**From:** [Cascade Irrigation](#)  
**To:** [Jeremiah Cromie](#)  
**Subject:** RE: CU-22-00002 Calvary Ellensburg - Notice of Application  
**Date:** Thursday, May 19, 2022 1:07:49 PM

**Date:** May 24, 2022  
**To:** Jeremy Cromie, County Planner II  
**From:** Craig Jones, City Development Coordinator *CJ*  
**Through:** Derek Mayo, City Engineer *DM*  
**Re:** Calvary Church Expansion – CU-22-00002

**SUBJECT: WDFW COMMENTS ON CU-22-00002 CALVARY ELLENSBURG**

TO: All Staff  
FROM: Public Works Plan Review Team  
DATE: June 6, 2022  
SUBJECT: CU-22-00002 Calvary Ellensburg

# CITY OF ELLENSBURG PUBLIC WORKS DEPARTMENT UTILITY MAP REQUEST INFORMATION

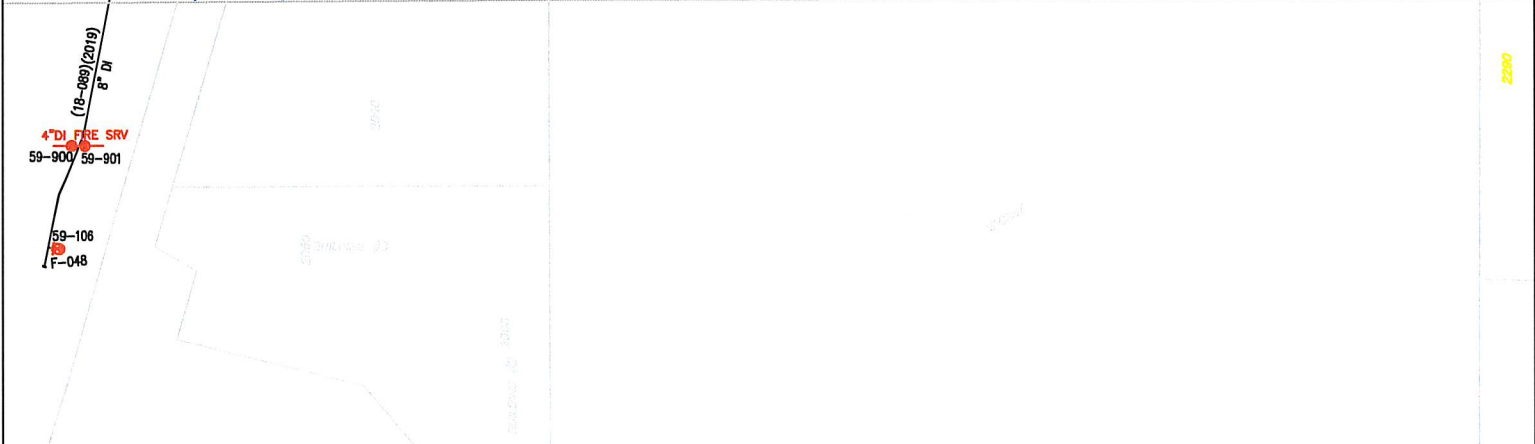
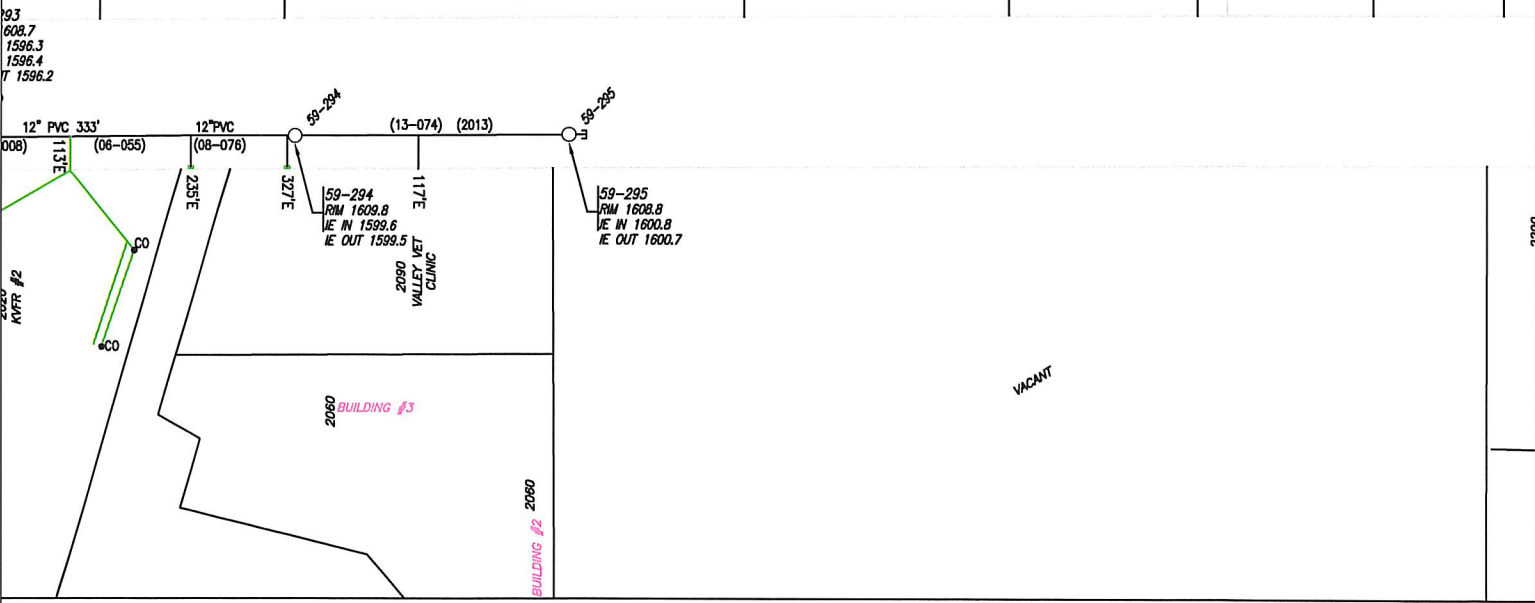
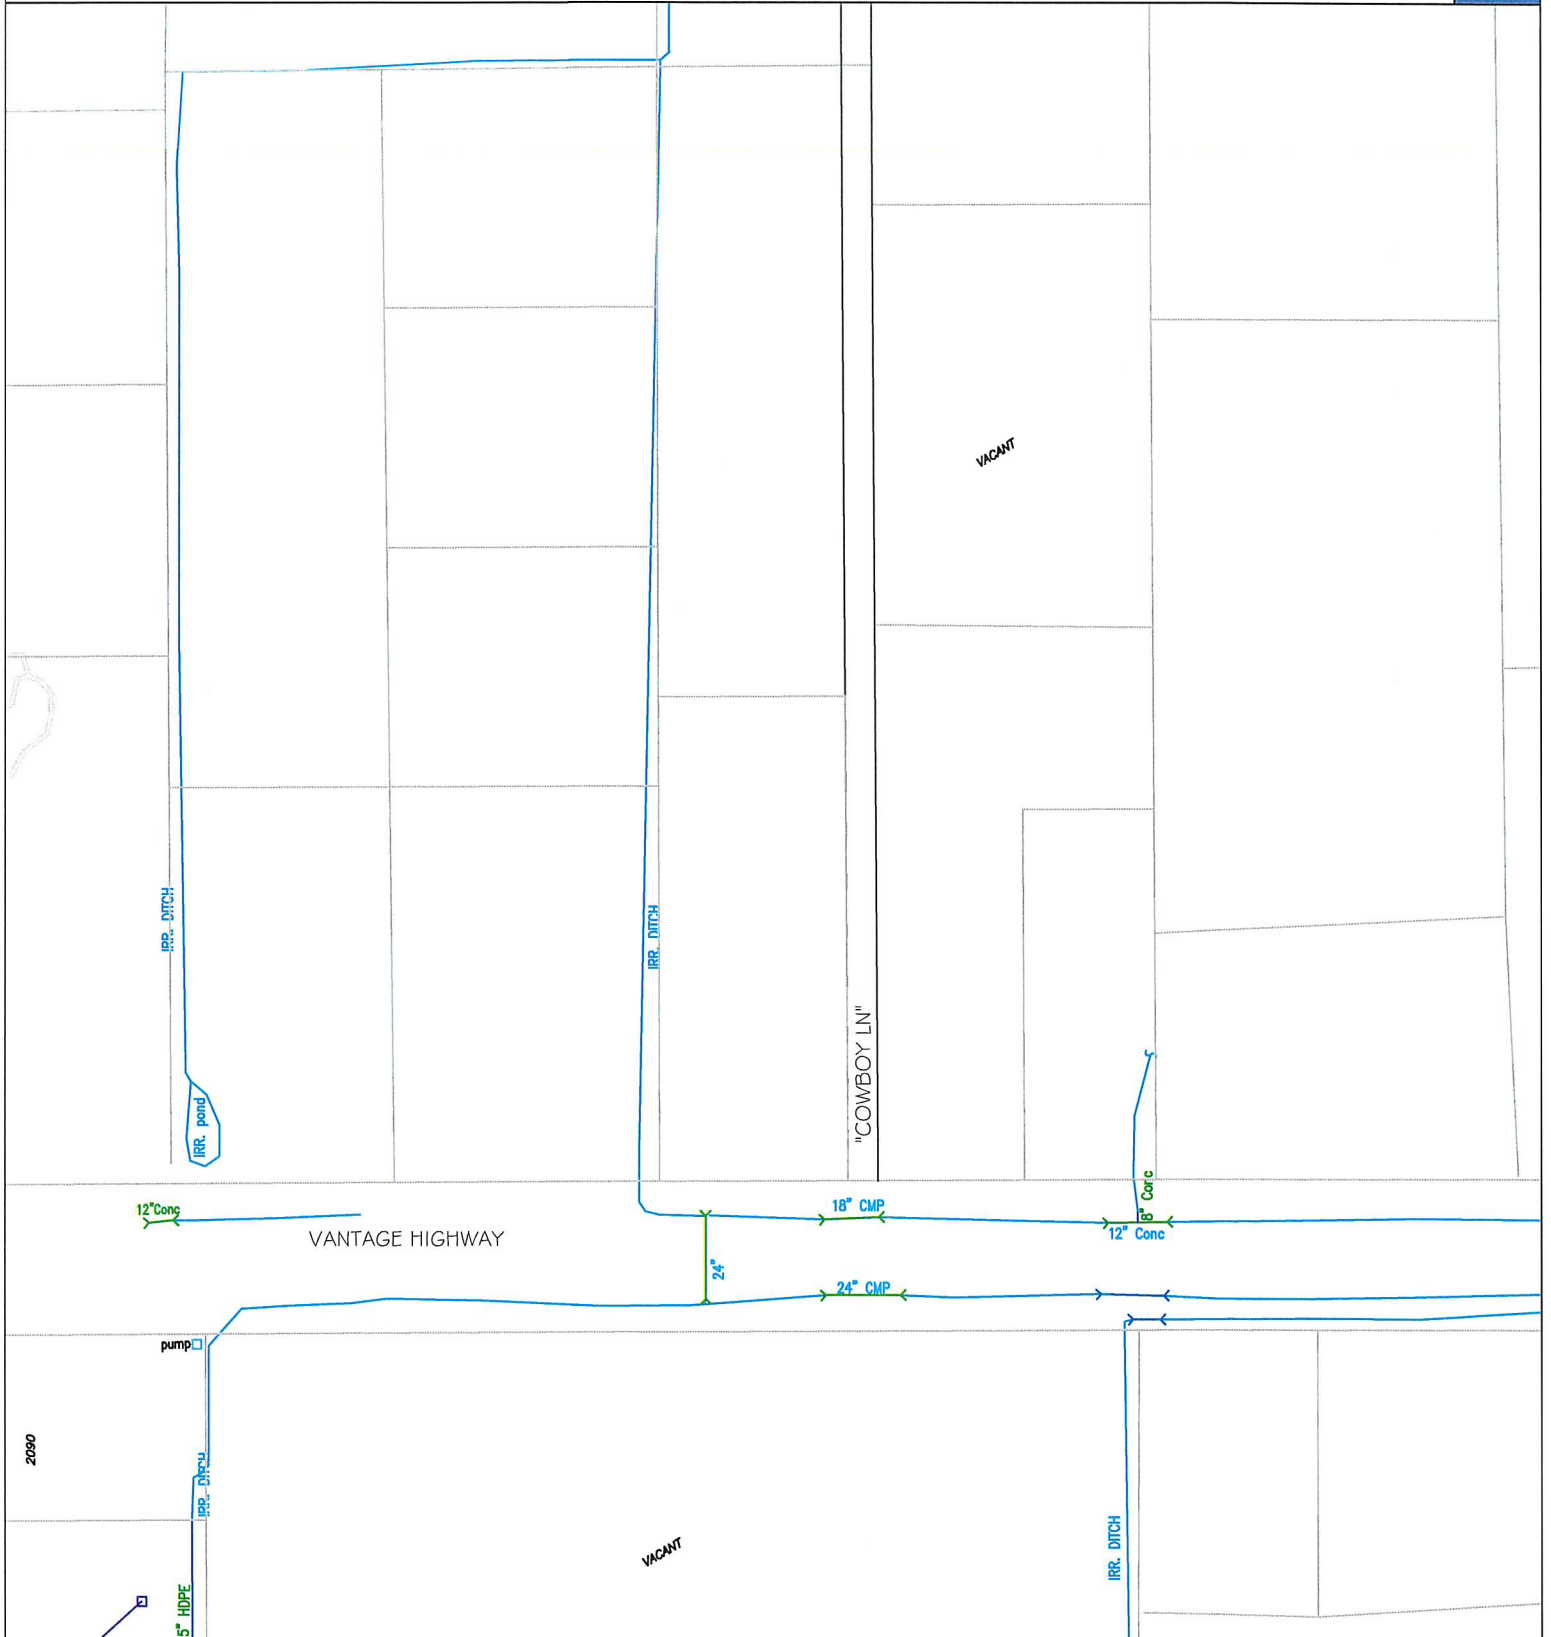
The water main available to serve this development is a 12" Ductile Iron main that runs in Vantage Hwy and stops approximately 680'+/- from the proposed project. The developer will need to extend the main to the farthest east extents of the property being developed along Vantage Hwy. The existing buildings on site will need to connect to City water. See attached utility map.

The sewer main available to serve this development is a 12" PVC main that runs in Vantage Hwy and stops the same location as water. The developer will need to extend the sewer main to the farthest east extents of the property being developed. The existing buildings on site are served by an onsite septic system that will need to be abandoned and connected to City. See attached utility map.

There is a drainage ditch along the south side of the parcel. Stormwater outfall could be discharged here after on site treatment and flow control were met. See attached utility map.

**Figure 1.** The blue line generally traces the path of East Branch Lyle Creek flowing into and off Calvary Ellensburg properties.

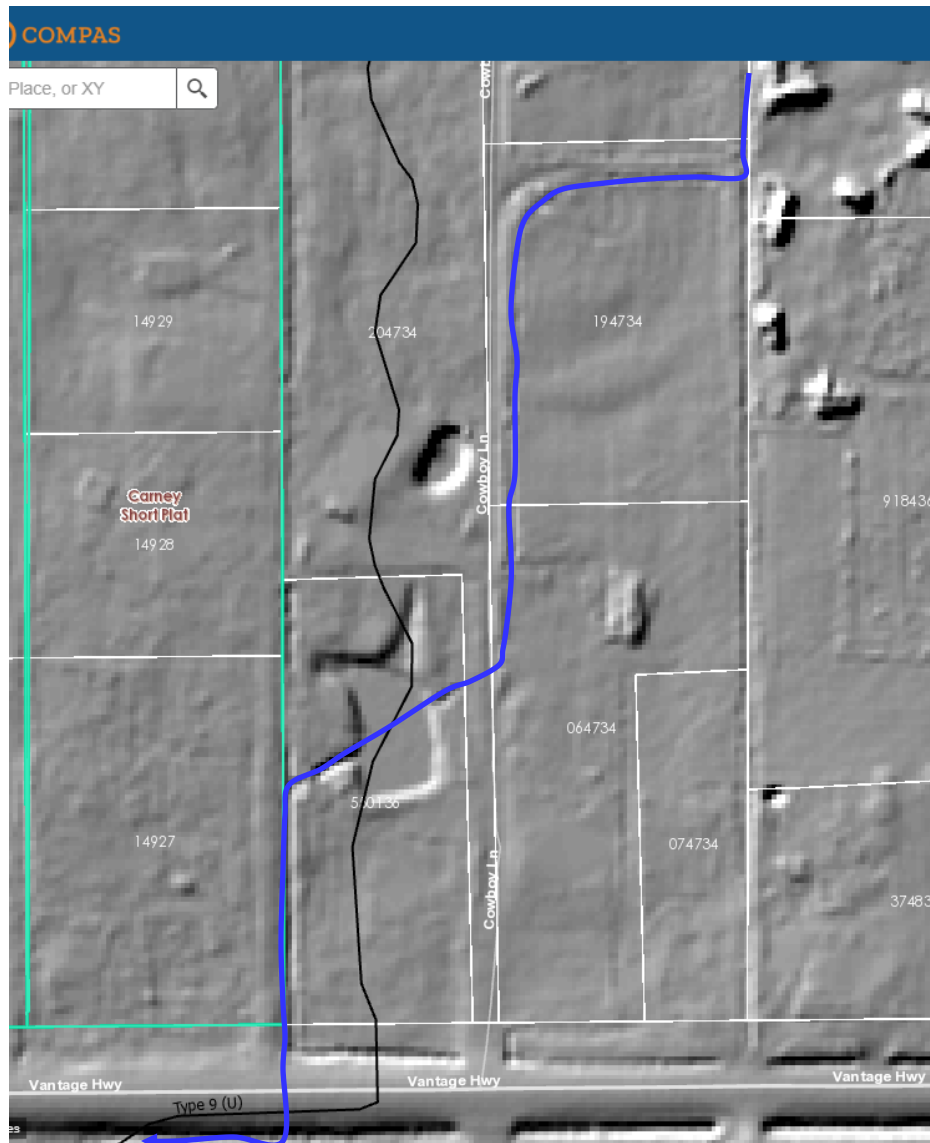
Thank you for the opportunity to comment on the proposed Calvary Ellensburg project near East Branch Lyle Creek. East Branch Lyle Creek is a branch of Lyle Creek starting along Judge Ronald Road. It flows south and continues west along the northern portion of Calvary Ellensburg's property before heading south and crossing Cowboy Lane to the west and eventually crossing Vantage Highway before rejoining the main branch of Lyle Creek near the Palouse to Cascades Trail. The stream layer on COMPAS does not accurately reflect the location of this channel, but the approximate location is easier to see in LIDAR and in Figure 1 below.

The Washington Department of Fish and Wildlife (WDFW) acknowledges that East Branch Lyle Creek may be managed for irrigation deliveries, but it is currently unscreened at Judge Ronald Road where the upstream extent of East Branch Lyle diverts from the main branch of Lyle Creek and it flows perennially. As such, WDFW recommends East Branch Lyle Creek be treated as a fish bearing stream with appropriate setbacks or that a fish screen meeting WDFW criteria to prevent fish entrainment into this channel be designed and constructed such that fish are no longer entrained into East Branch Lyle Creek. WDFW will be pleased to work with the project proponents to evaluate options and help accomplish their goals for their property.

Calvary Ellensburg Proposed Site Plan Phase I - Exhibit B

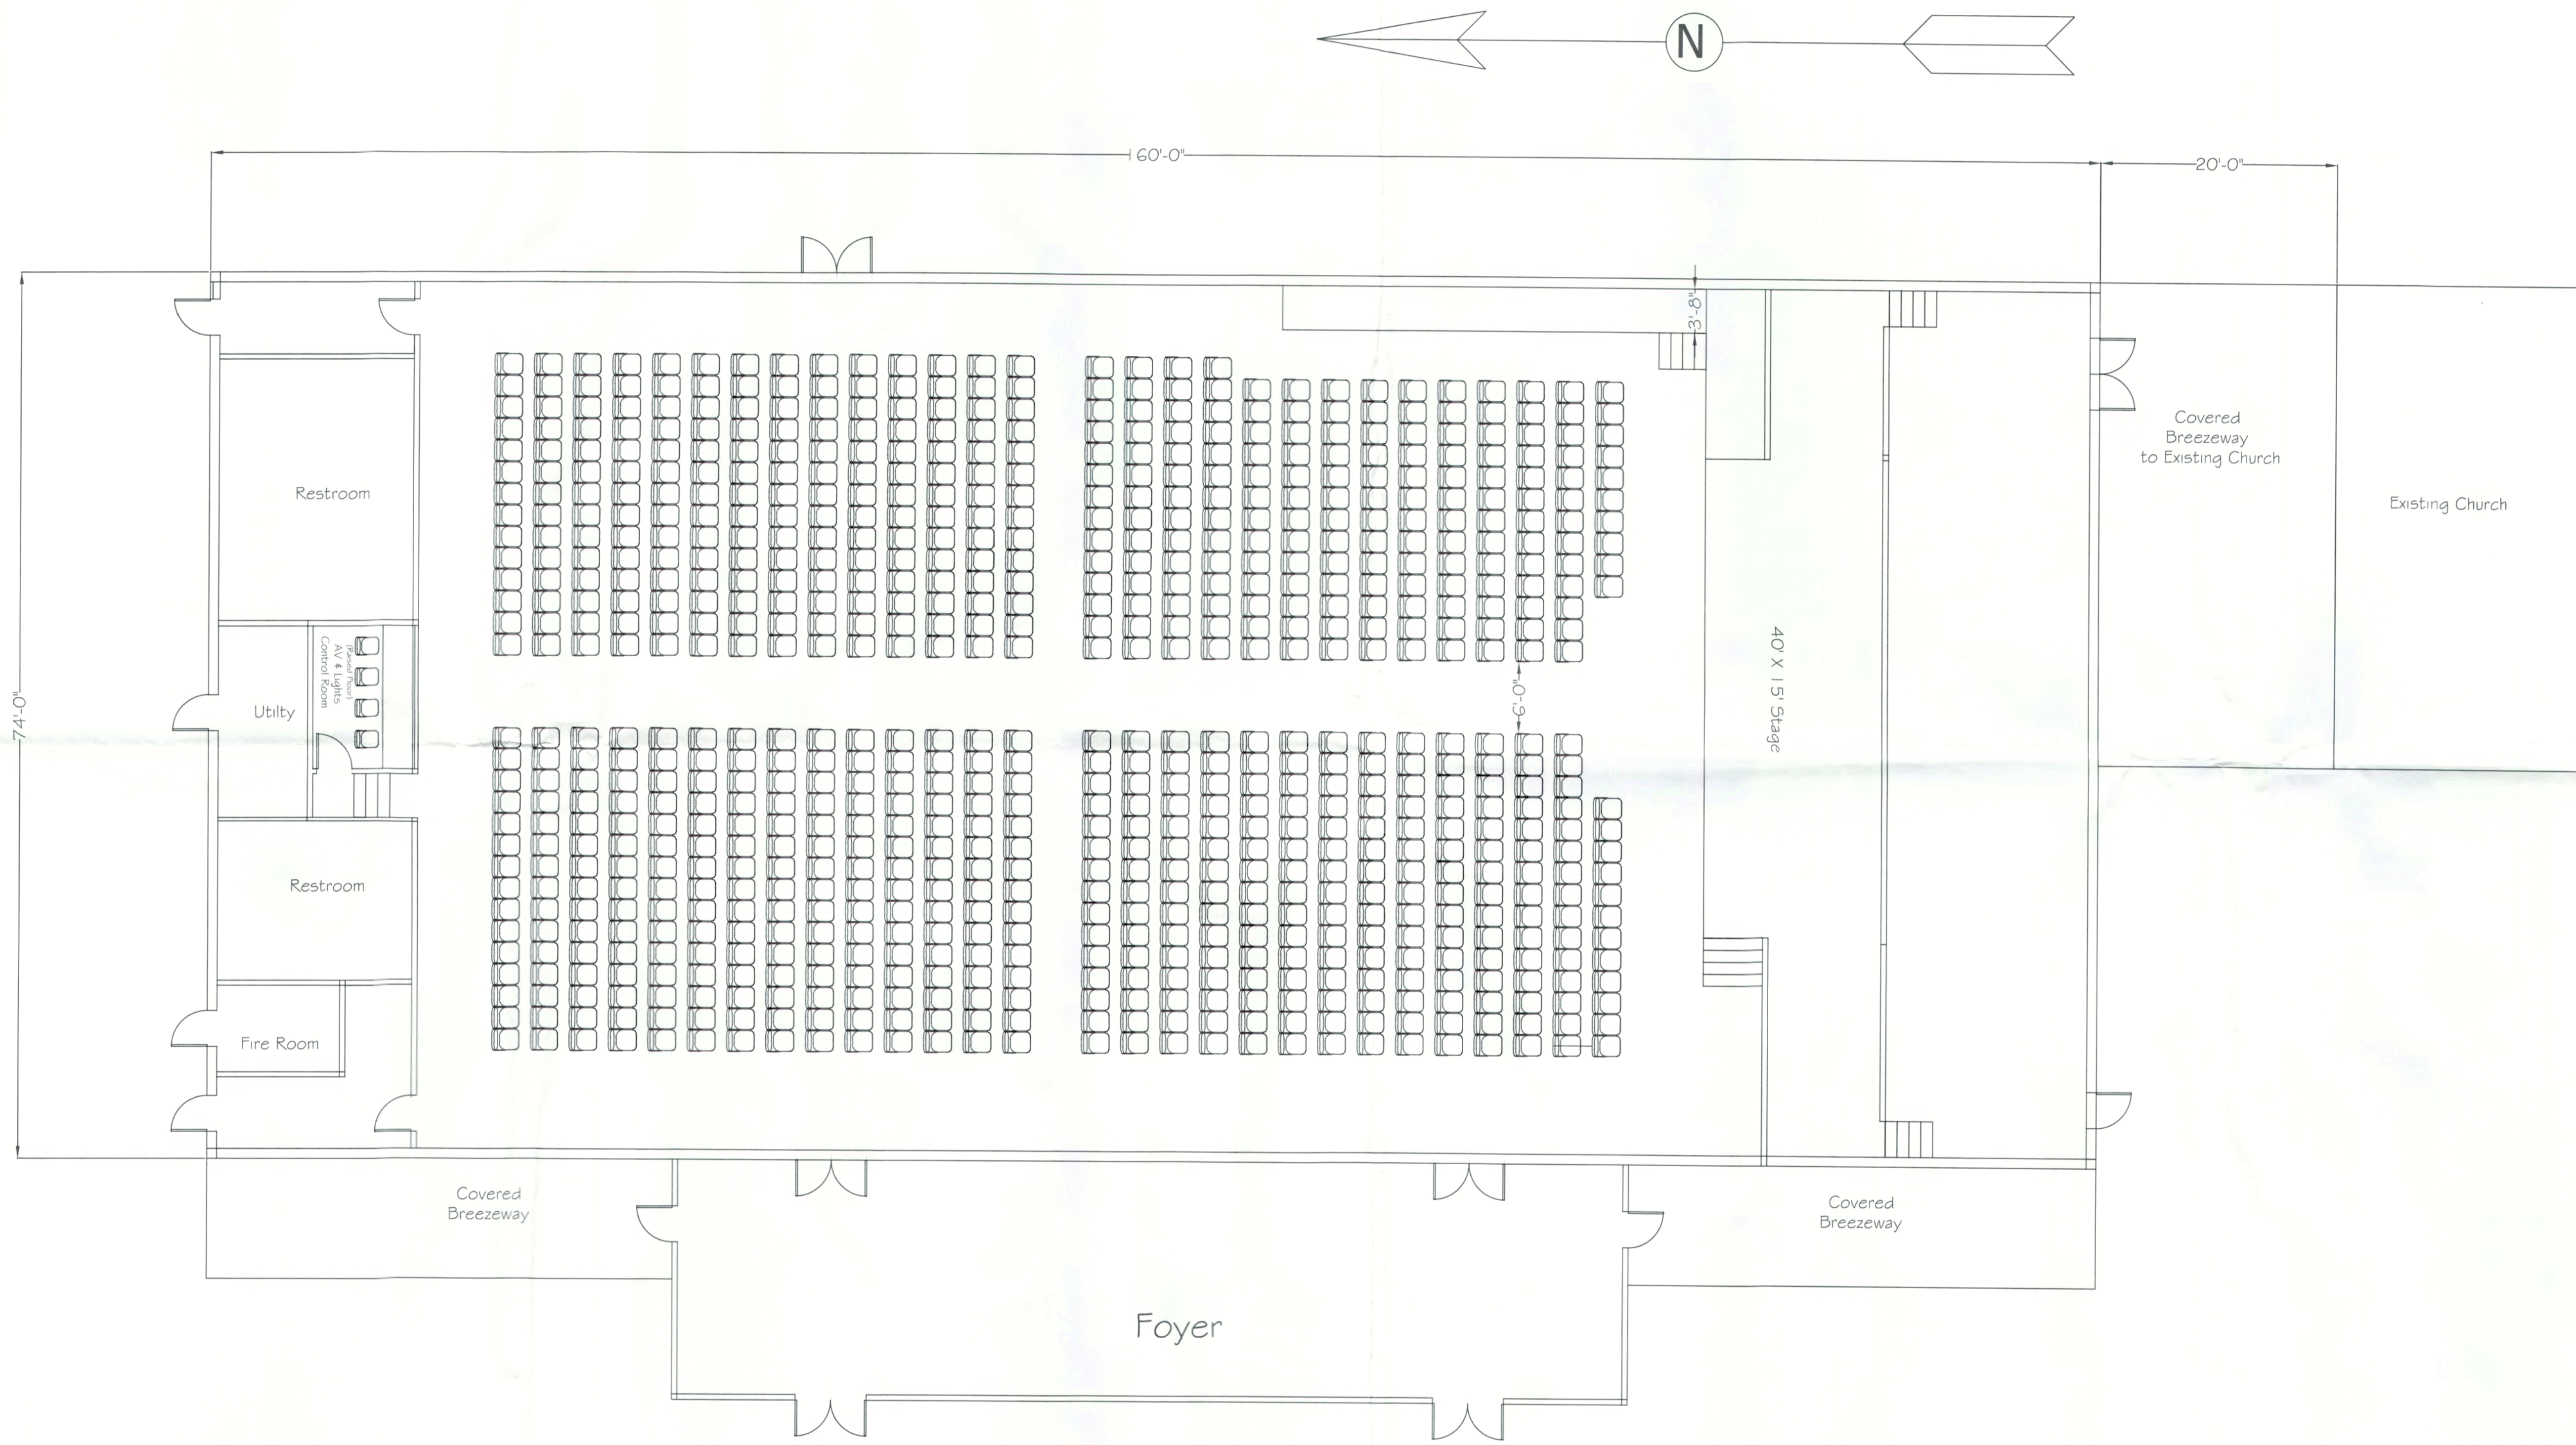
8. Fire Hydrants based on sq. ft. of buildings and required flows based on IFC Section 5, Appendix B and C. As currently designed the site would require additional hydrants. There must be a hydrant within 100' of FDC connections. Consult City of Ellensburg Fire Marshal for preferred location.
